**WEST SUSSEX COUNTY COUNCIL
COUNTY HIGHWAYS CONSULTATION RESPONSE**

**SUBJECT: AL/123/17/PL - Demolition of existing dwelling & erection of 1
No. dwelling (resubmission following AL/83/17/PL).**

Mildmay, Hook Lane, Aldingbourne, PO20 3TE

DRAWING TITLE:
SITE LOCATION AND BLOCK PLAN

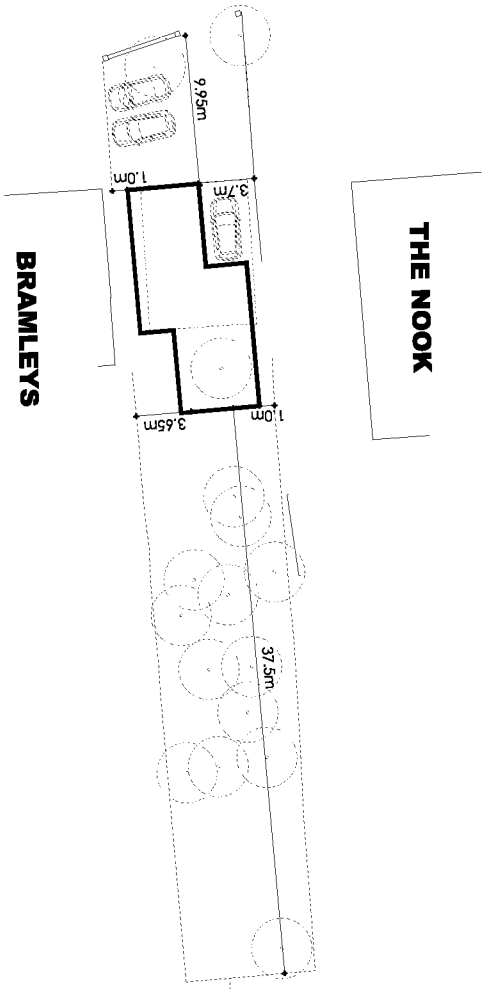
An appropriate quantity of on-site parking is proposed. The dwelling should also be provided a secure and covered cycle parking provision.

The application form indicates that no changes are to be made to the existing vehicular access arrangements. The design and access statement details that access will be achieved via existing crossovers.

The block plan provided clearly shows a vehicular access point at the norther extent of the western boundary onto Hook Lane, adjacent to The Nook. From inspection of the site photos provided within the design and access statement the site seems to benefit from an access point at the southern extent of the site on the western boundary adjacent to Bramleys.

The applicant should clarify the existing and proposed access arrangements so that an appropriate assessment can be made and appropriate conditions and informative notes advised.
